David Way  
Department of Planning, Industry and  
Environment  
Locked Bag 5022  
PARRAMATTA NSW 2124

**Subject:** Exhibition – Environmental Impact Statement for the New Liverpool Primary School (SSD-10391)

SCALE 1:500 @ A3 Figure 6. Planting plan 1 of 2

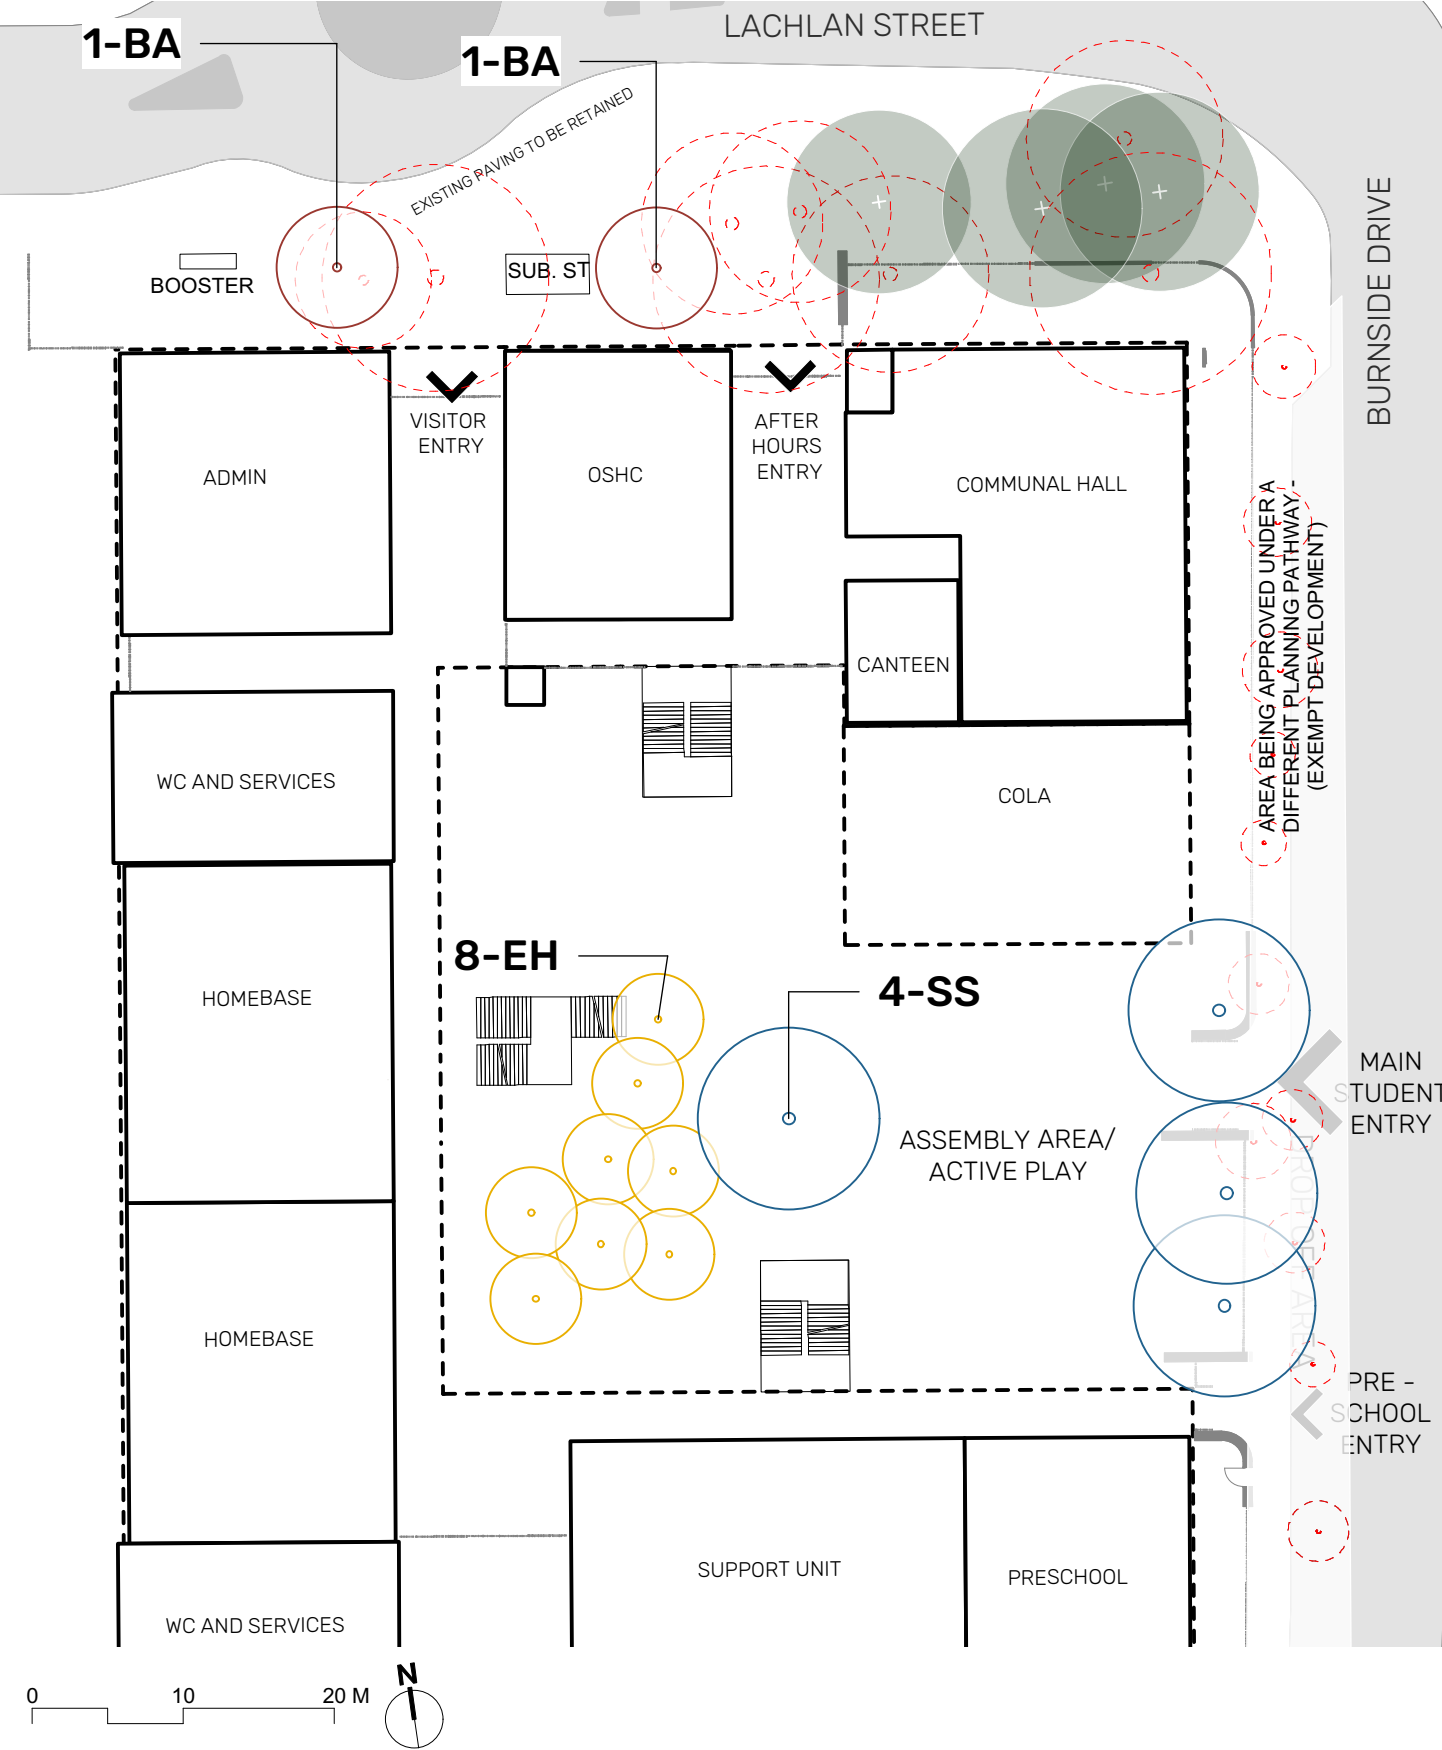
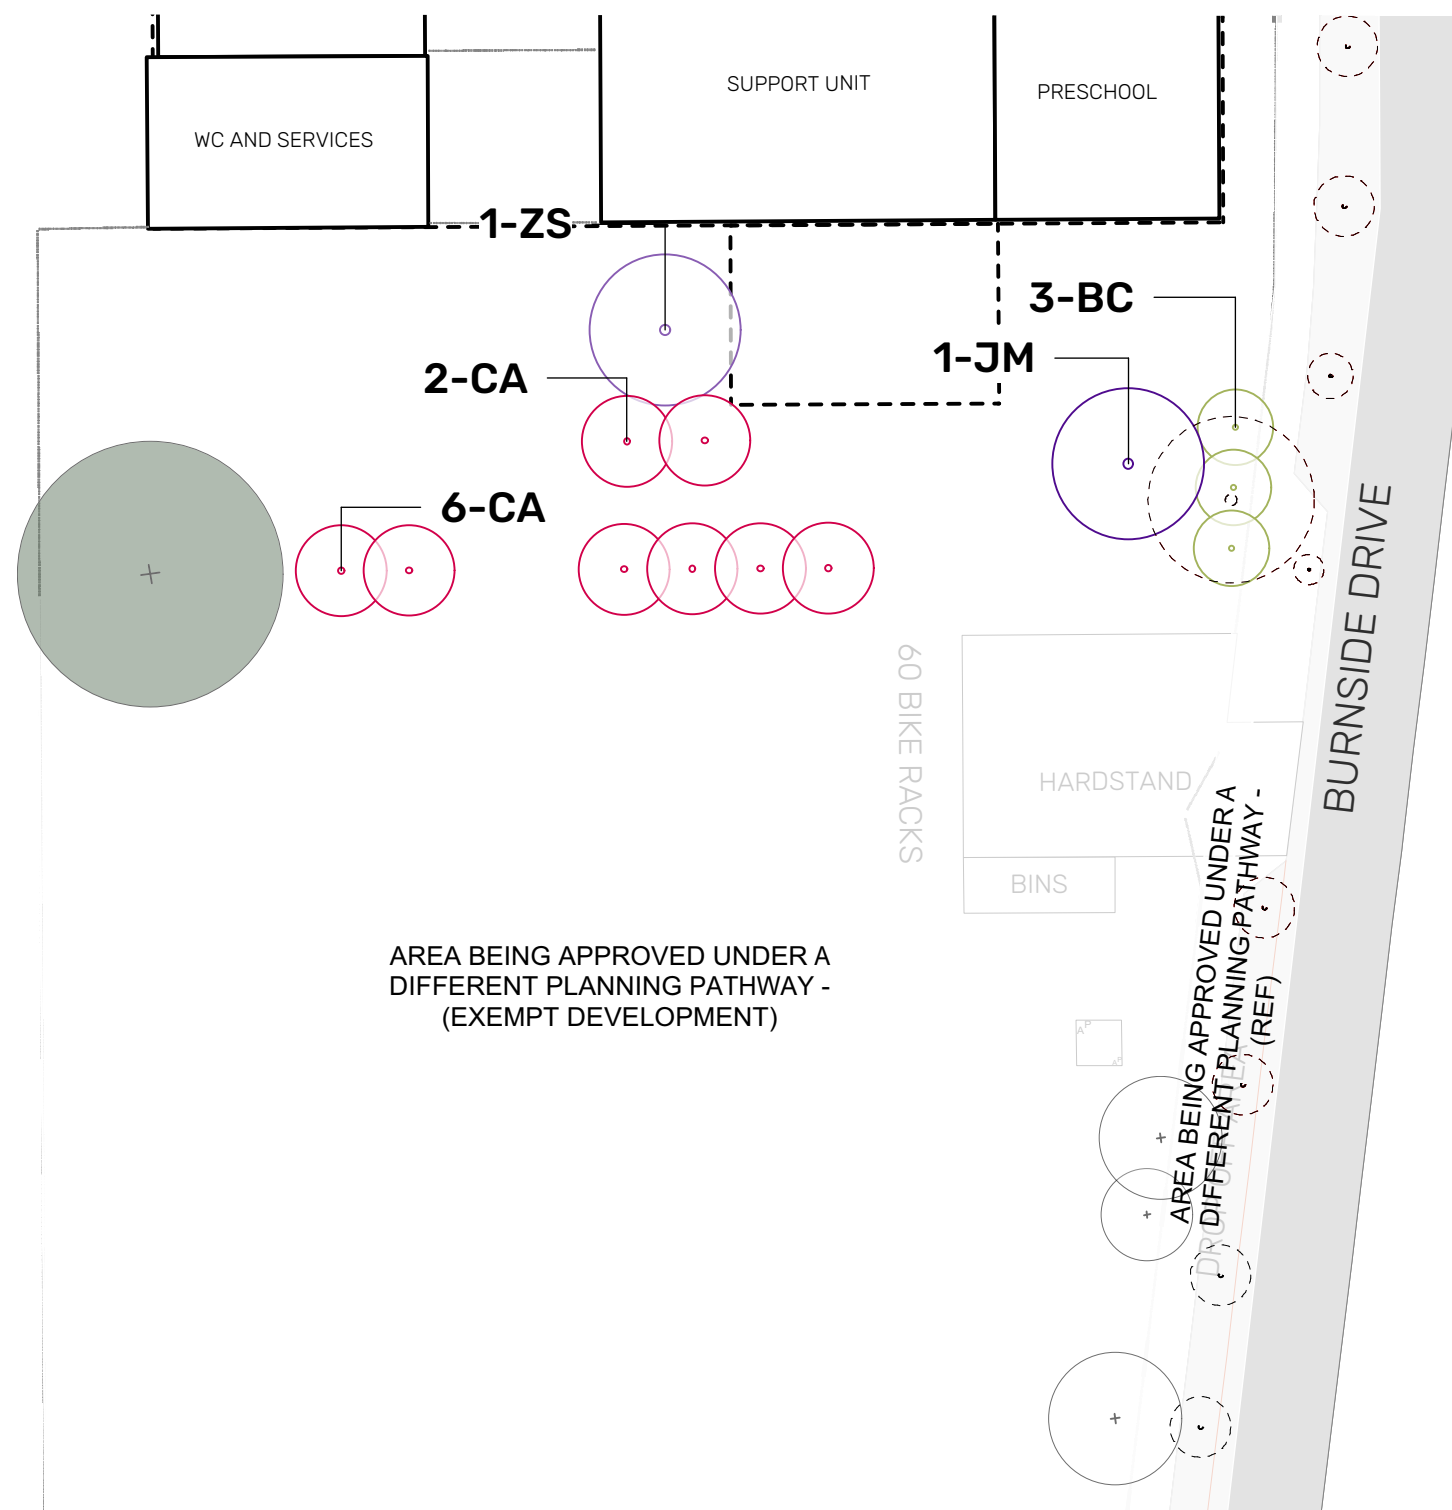
EES does not support the planting of Chinese Tallow Tree on the site as they are classified as weeds: <https://weeds.dpi.nsw.gov.au/Weeds/Details/38>. EES recommends the *New Liverpool Primary School Landscape Concept Design report* (spackman mossop michael, May 2021) be amended to substitute Chinese Tallow Tree for a native species.
